**North Yorkshire County Council and Richmondshire District Council**

**The Councils' response to the Applicant's response to the  
Examining Authority Written Questions for Deadline 4 – to be submitted to Deadline 5**

This document represents a table of responses to Applicant’s responses to the Examining Authority’s Written Questions [REP4-011] to be submitted to Deadline 5. It has been prepared jointly by North Yorkshire County Council (“NYCC”) and Richmondshire District Council (“RDC”) together as the “the Councils” to set out further comments considered necessary in detailing the impacts upon the local area of the Applicant’s proposed A66 Northern Trans-Pennine Project (“the Project”), which has been submitted for Development Consent. The Councils comments for Deadline 5 are entered in the right-hand column

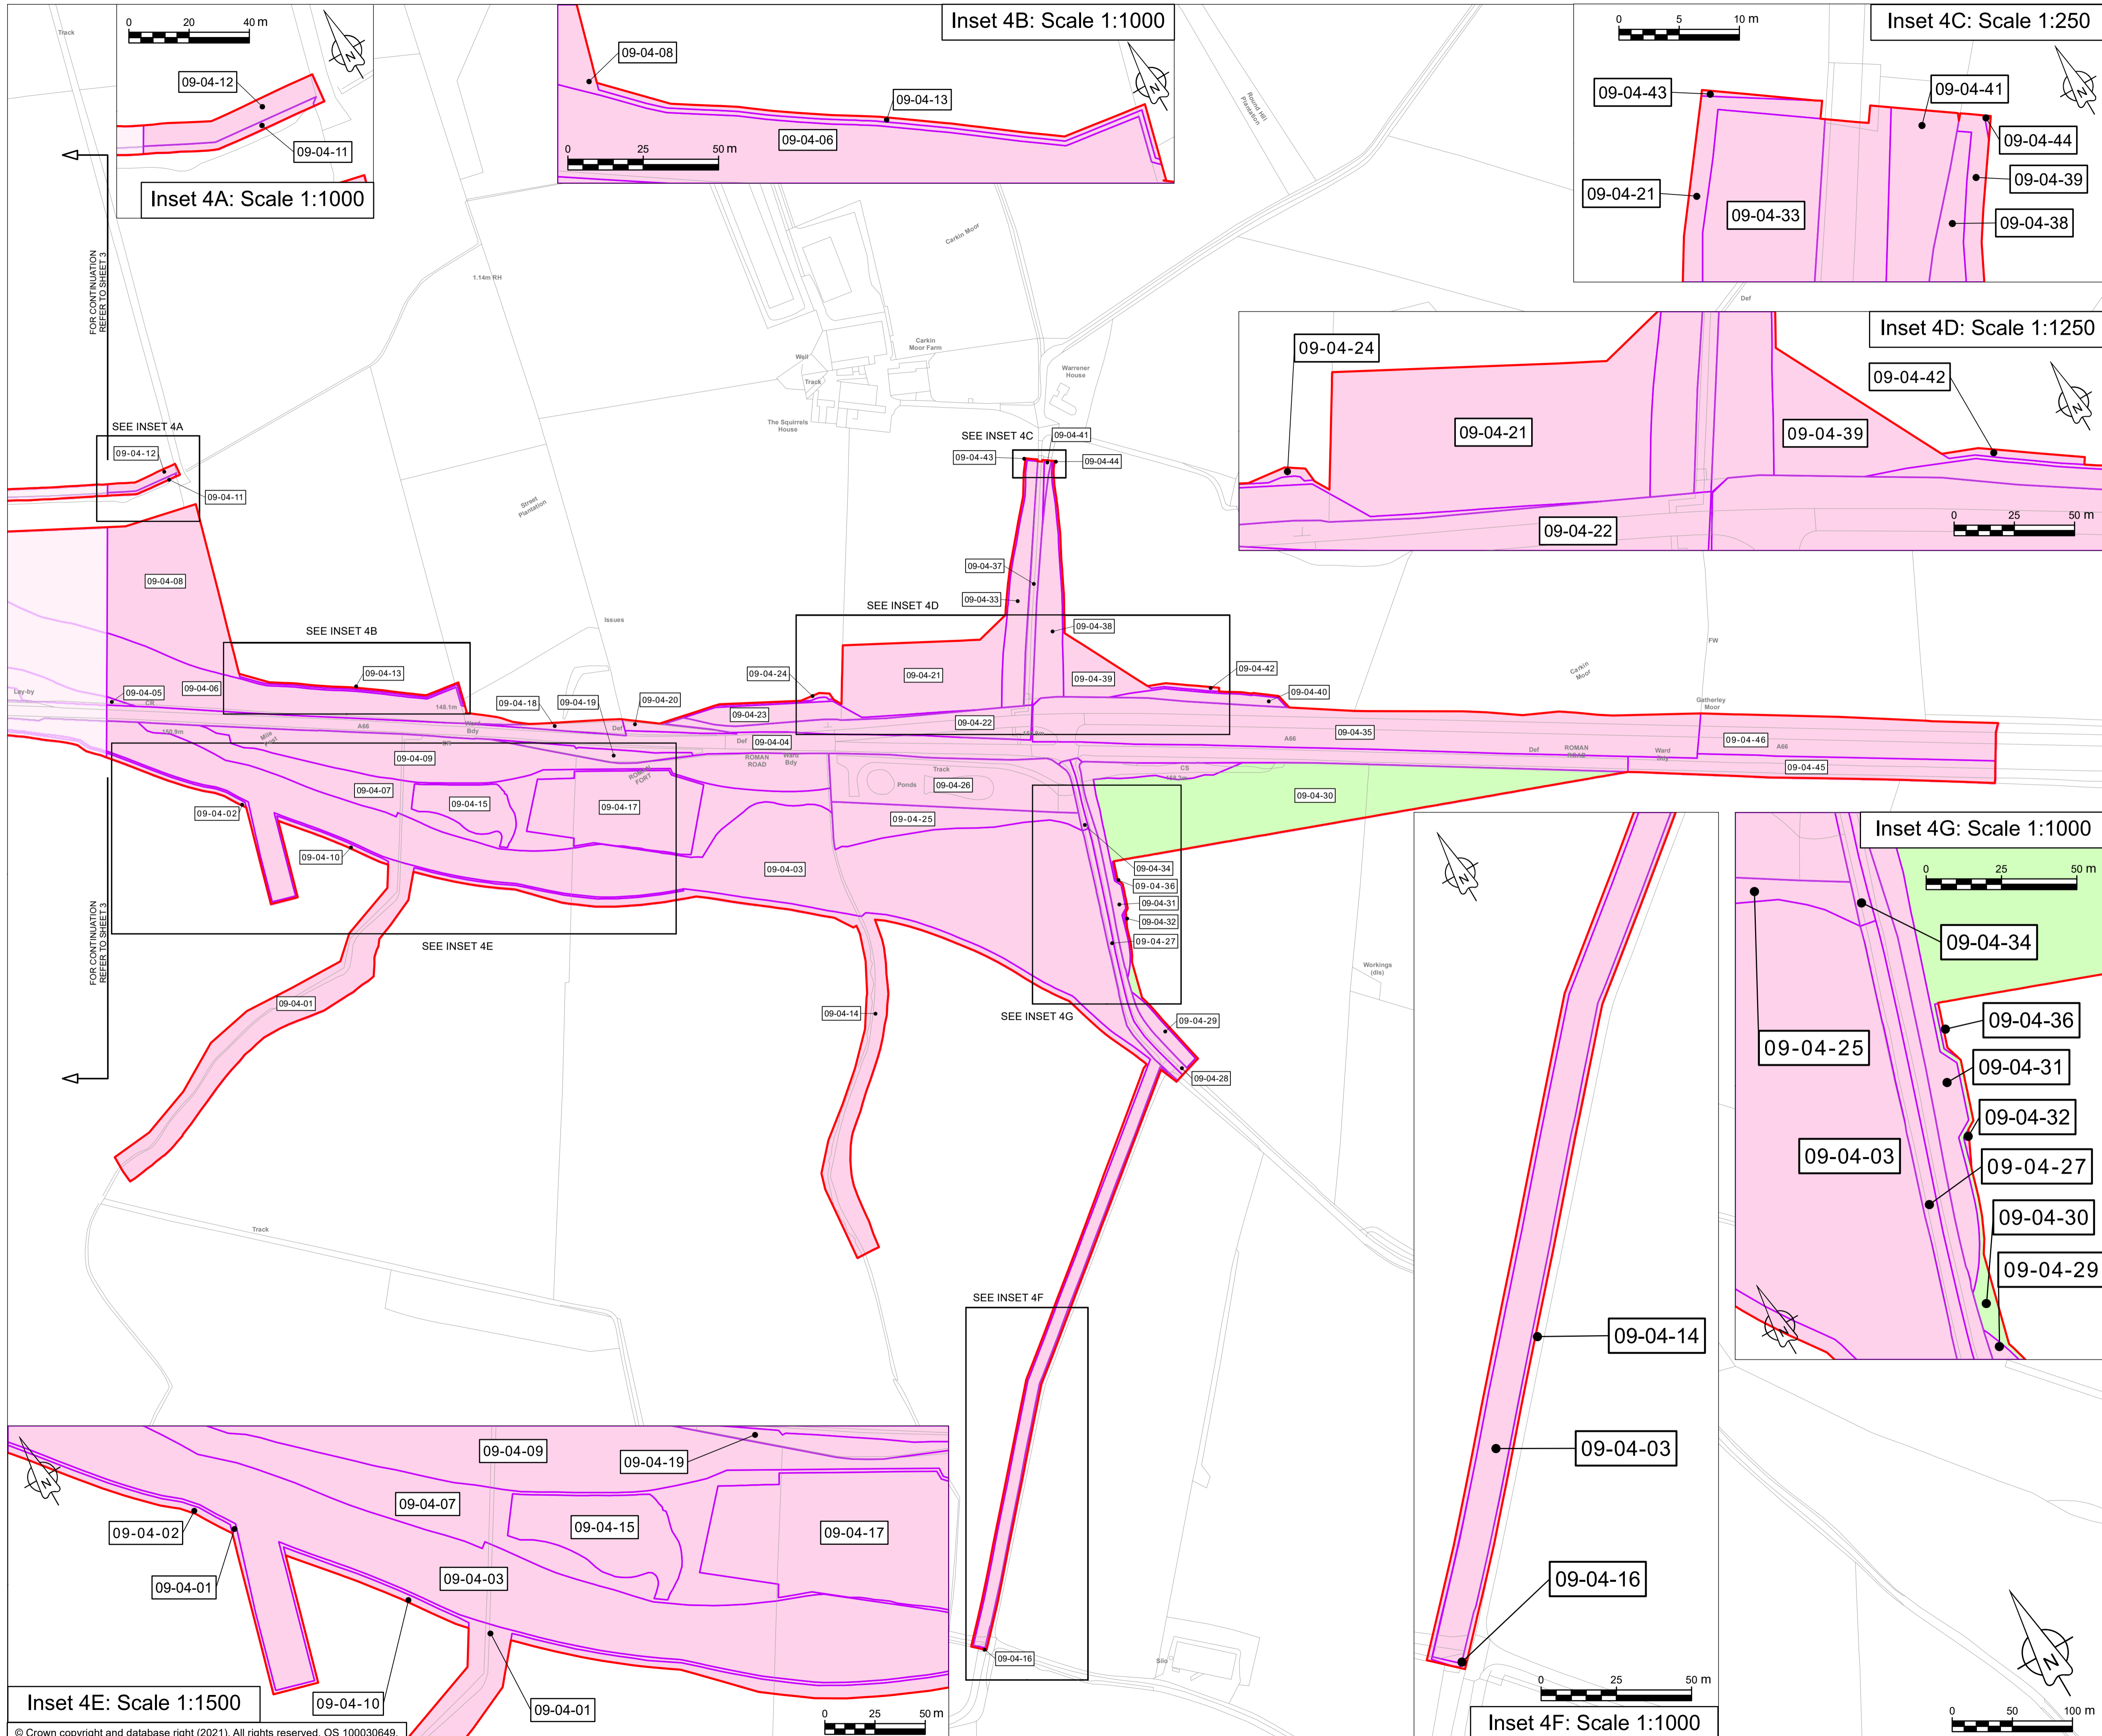
CA 1.6	Need for CA	Explain why CA is being sought on Plot 09-03-26 [APP-310, Sheet 3].	The Compulsory Acquisition and Temporary Possession Schedule sets out that Plot 09-03- 26 is required to facilitate the construction of new carriageway on the de-trunked A66 and works to stop up redundant lengths of the de-trunked A66, equestrian track and private means of access and the provision of landscaping and reprofiling. (5.9 Compulsory Acquisition and Temporary Possession Schedule, APP-300). More specifically, plot 09-03-26 has been identified as being required during construction to host a temporary construction compound as illustrated on 2.5 General Arrangement Drawings Scheme 09 Stephen Bank to Carkin Moor, Sheet 3 of 4, (APP-017) and thereafter is required for essential environmental mitigation. The Applicant acknowledges that the Environmental Mitigation Maps for Scheme 09 (Sheet 3) show this area of land as blank. This is a drafting error that will be		The purpose of the CA is understood by the Authorities and we have responded on this point previously.  The concern for the Authorities remains in relation to the details of the temporary compound. We understand that the compound is to be the main compound for whole scheme. At this point details of the compound are not known. The site is close to the villages for which the town council has expressed concern about the overall project and we expect there will be a significant amount of local interest.

Ref No	Subject	Question	Applicant's Response	Author	Councils' further comments (proposed / draft)
			corrected via errata.		<p>The Authorities have only received this information since the DIPS have been appointed (Nov 22) and therefore we are concerned about the level of accurate consultation at will take place</p> <p>We understand that the application is coming forward as a town and county planning act application and is therefore outside of the DCO application. Consultation will take place as a matter of course under the TCPA however it is not clear what will happen if that application is refused. If the compound would go ahead as part of the DCO, simply later in the process, this would understandably not be acceptable to the local community and be very difficult to reconcile</p> <p>Clearer understanding is needed on the process. At this point the authorities await pre application for the compound.</p>
